WRITTEN REPRESENTATION FOR DEADLINE 1 – 20 MAY 2025

PLANNING INSPECTORATE REFERENCE NUMBER: EN020028

MADE ON BEHALF OF D LUND AND M FARE FARMING PARTNERSHIP

The relevant document of reference is MORGAN AND MORECAMBE OFFSHORE WIND FARMS: TRANSMISSION ASSETS Environmental Statement Volume 1, Annex 4.3: Selection and Refinement of the Onshore Infrastructure

Drawing Number:
BP-GBR-MORG-REG-0176

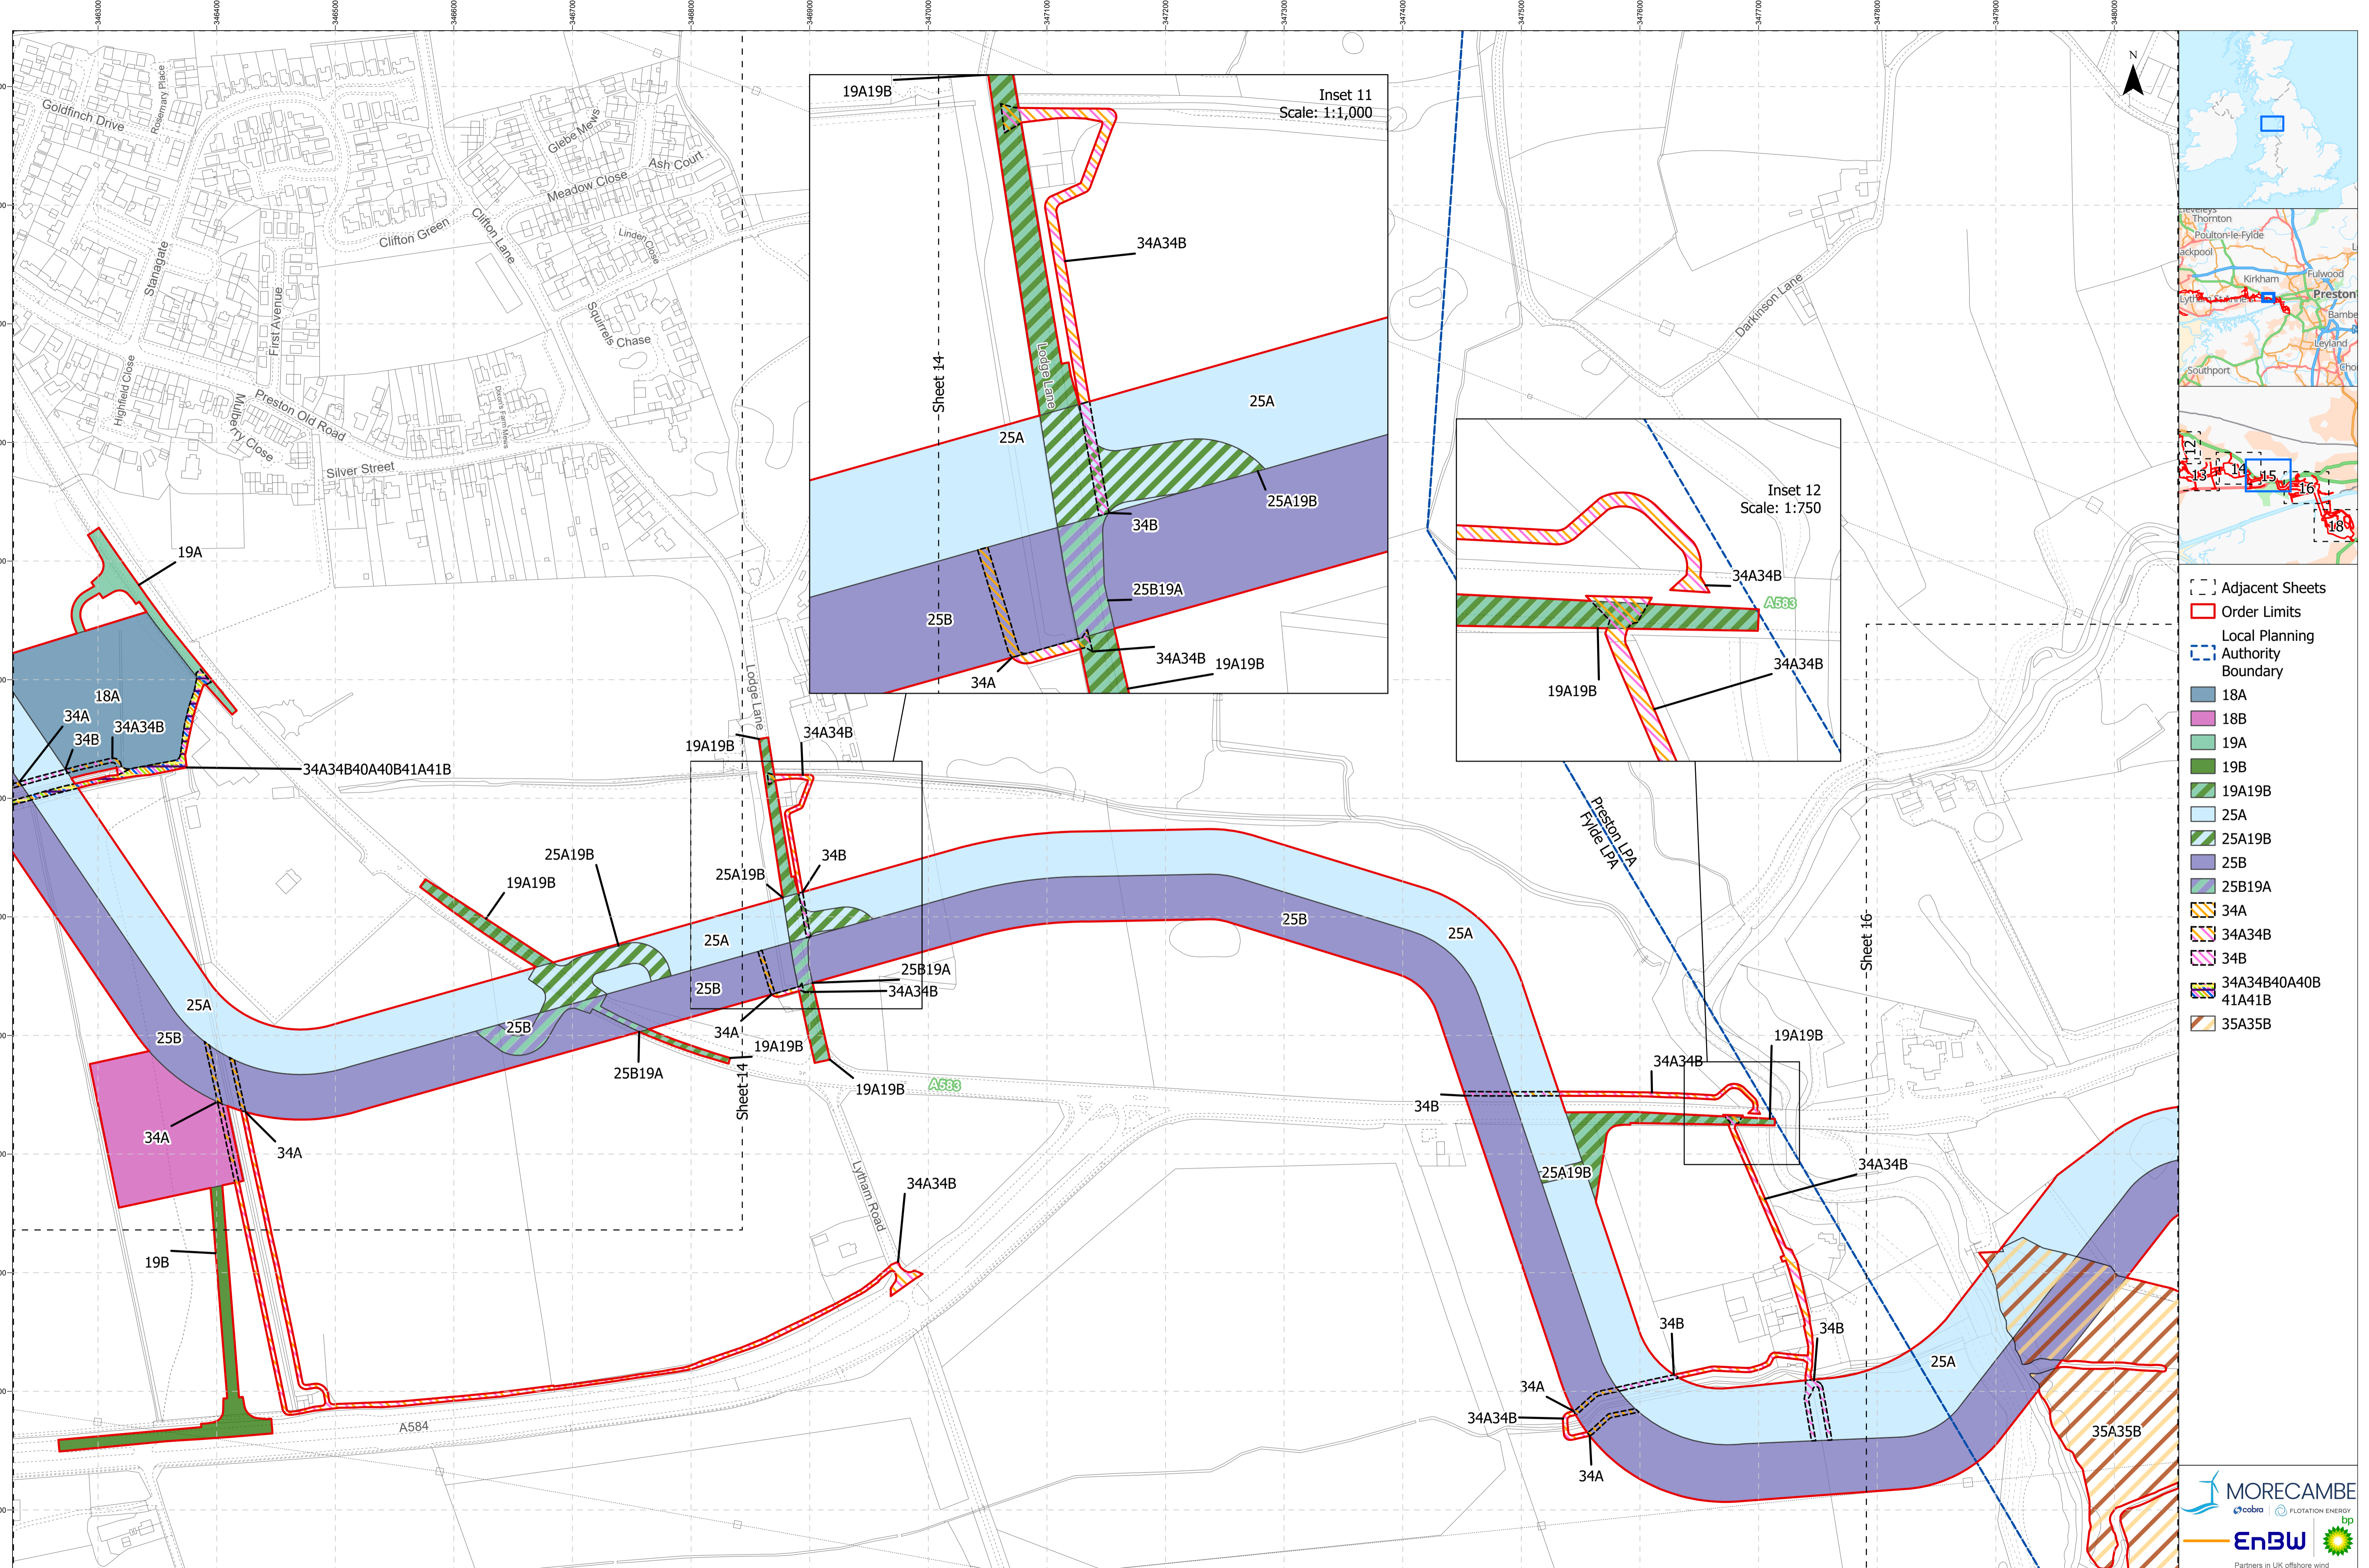
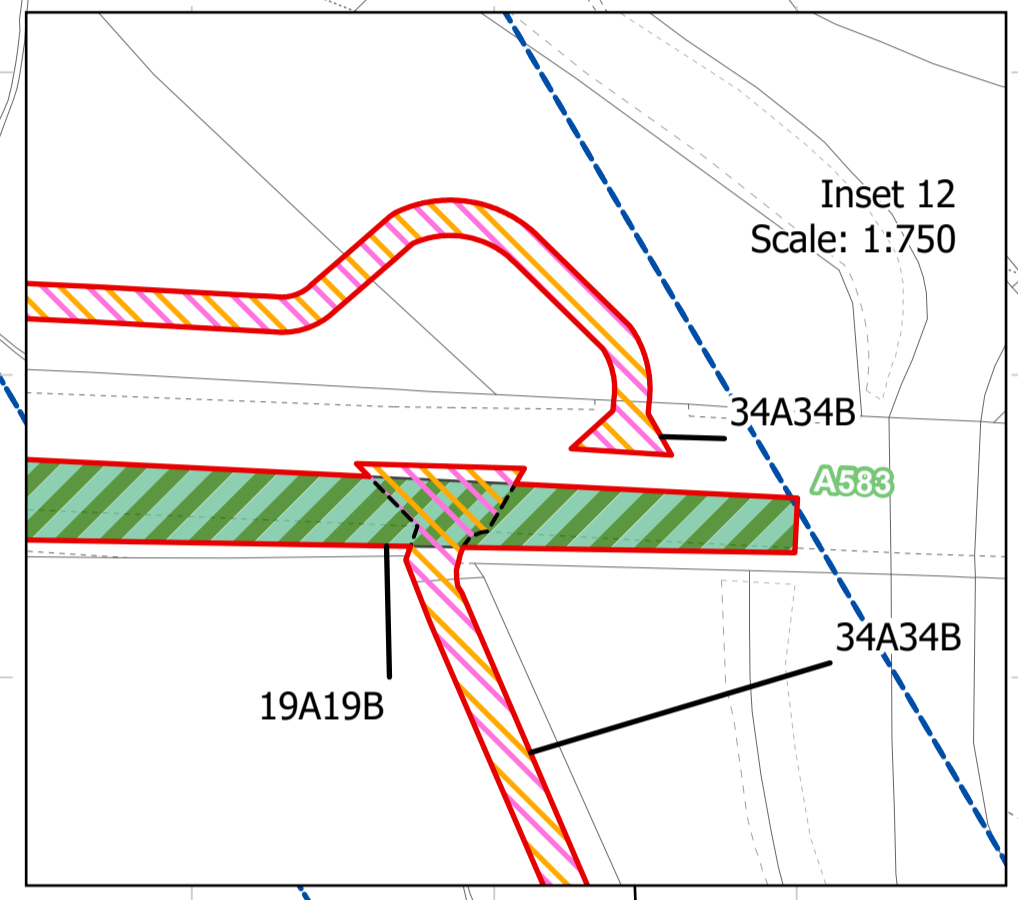
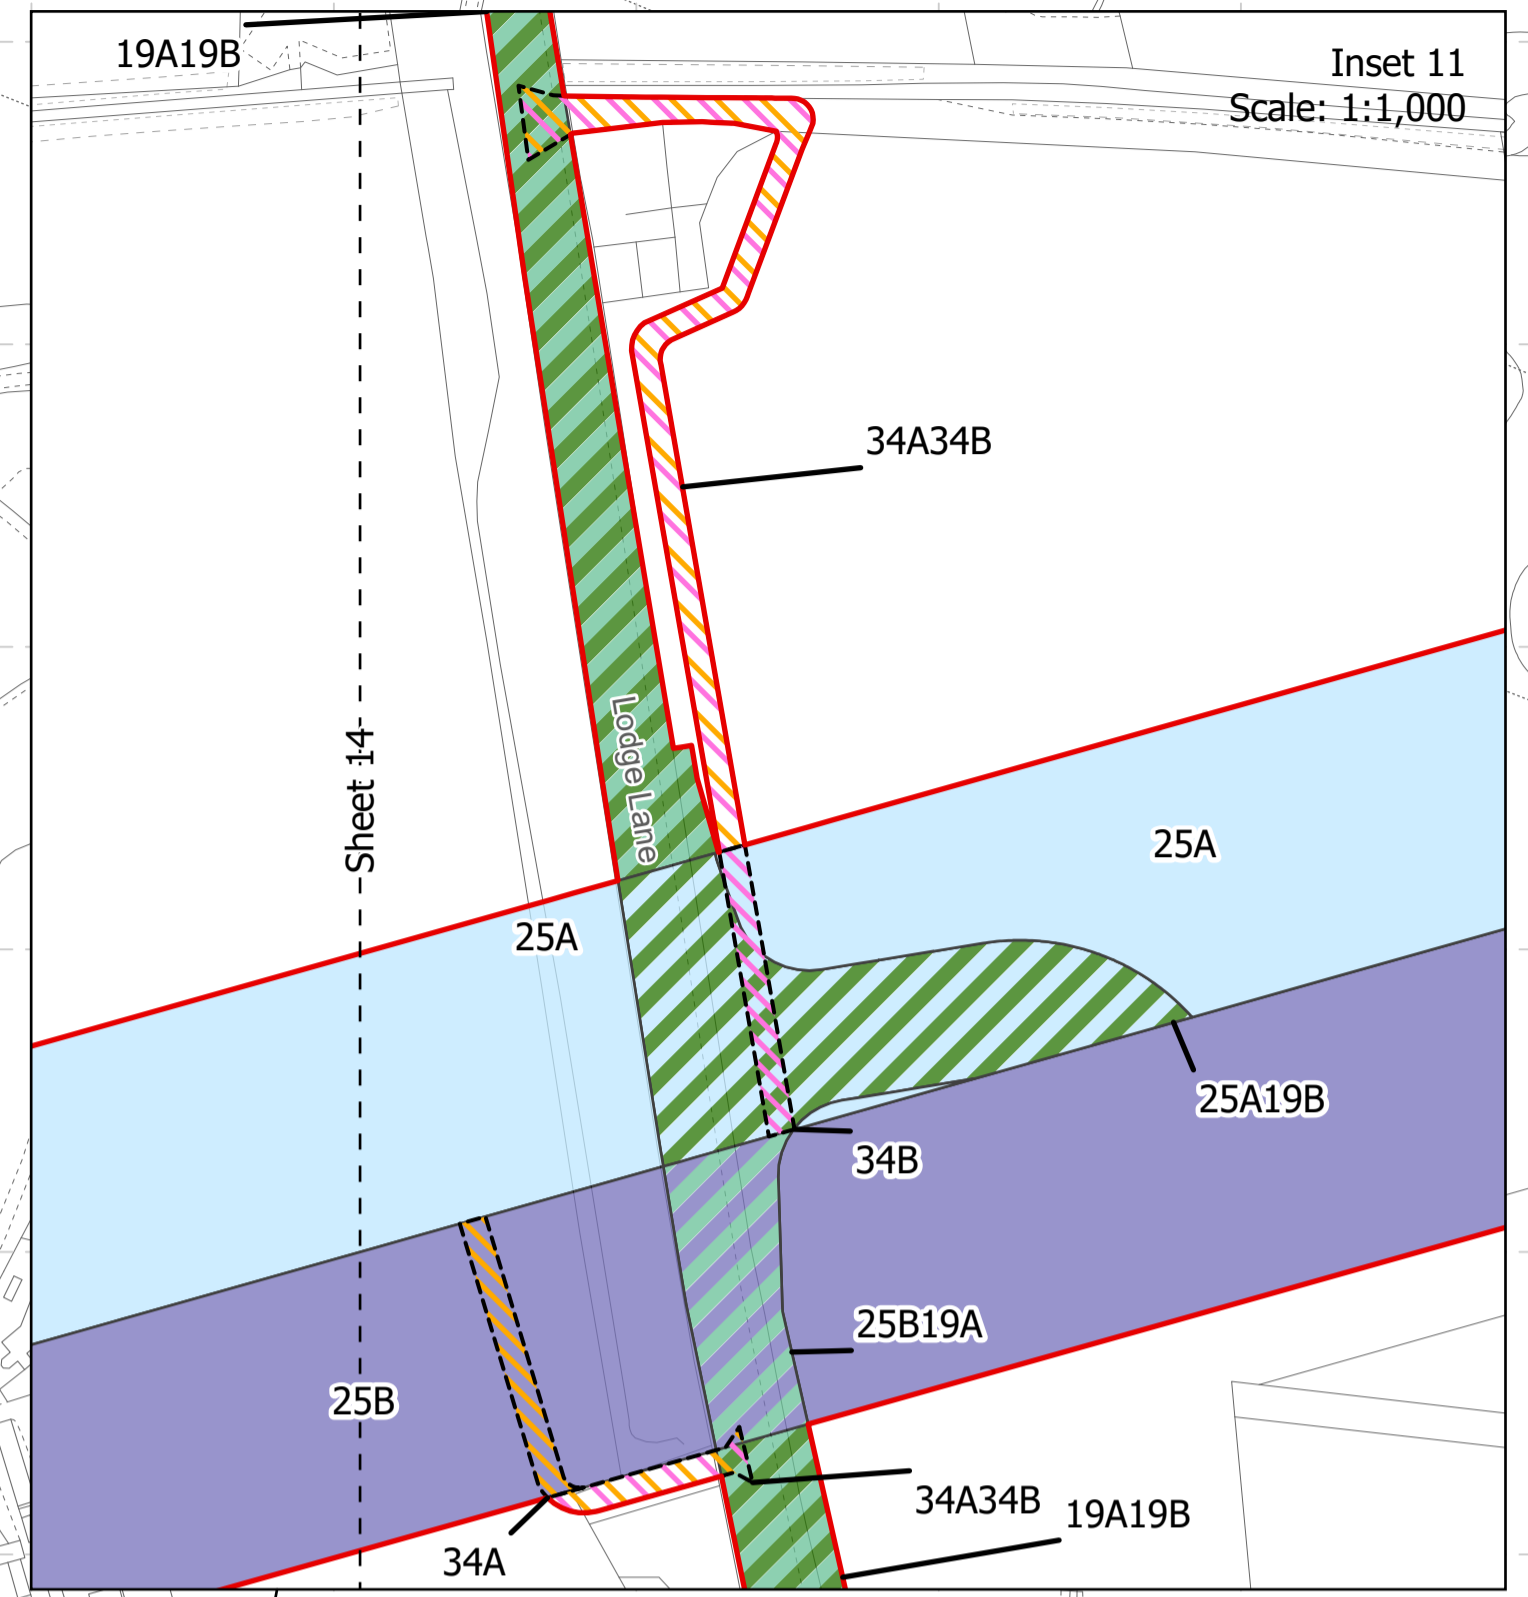
The Projects propose permanent access rights to access biodiversity mitigation areas over the private farm access road serving Greenbank Farm and Freshfield Farm identified as SI Works 34A40A41A. This proposed permanent access is wholly unnecessary as the Morgan Project will have permanent access from the A583. SI Works 34A40A41A impacts residential amenity and business security as the proposed vehicular access passes through residential properties off Lower Lane two residential farm properties and private farm yards.

SI Works 34A states –permanent access including— (a) creation and improvement of access to highway; and (b) works to visibility splays. What is meant by ‘creation’ as the private road exists and what is meant by ‘improvement’.

The existing green lane bridleway track which crosses the cable easement corridor to provide access to SI Works 49A south of Morgan substation is important as it links two farming businesses that work together (Lower House Farm and Greenbank Farm) therefore landowner requires to continue to have full use of this green lane.

This proposed permanent access is wholly unnecessary, shown coloured in red on the attached identification plan. We have proposed a much more suitable access shown coloured in green on the attached identification plan.

This biodiversity mitigation access route is to proposed mitigation area SI Works 49A which is in a wholly inappropriate location abutting Freshfield Farmhouse and causes loss of amenity countryside views to the south from Greenbank Farmhouse. There is no description of what this area is mitigating and there has been no prior discussion with the landowner at Greenbank Farm or Freshfield Farm for this proposed siting. It would appear that SI Works 49A is a biodiversity enhancement which is not a requirement for Project A as BNG is not a legal requirement. If the Projects had liaised with the landowner then there would have been a likelihood of jointly agreeing suitable location(s) for permanent environment mitigation works however this was not discussed/considered by the Projects until it was too late to amend the submitted plans. Proposed SI Works 49A should be relocated to an approximate location shown edged in purple on the attached identification plan which includes an existing pond/pit not previously identified on surveys.

SI Works 49A abutting Freshfield Farm was not known to us until it had been included in the DCO application SI Works. We made our enquiry dated 21 November 2024 to find out more about this mitigation proposal and the response from Dalcour MacLaren (DM) was that whilst this was not something their liaison officer was aware of he explained in an email that having looked it up it is to be a pond to mitigate loss of a pond.

At a site meeting with DM and Jacqui Stoddart Morgan representative on 5 February 2025 this pond mitigation was discussed and a potentially suitable alternative was found on site which had not been previously identified as a pond, however whilst this alternative appeared to be a suitable pond mitigation location yet again the Project advised that it was too late to revise the submitted plans. We request that proposed SI Works 49A abutting Freshfield Farm is relocated to the identified suitable location. shown edged in purple on the attached identification plan which includes an existing pond/pit not previously identified on surveys.
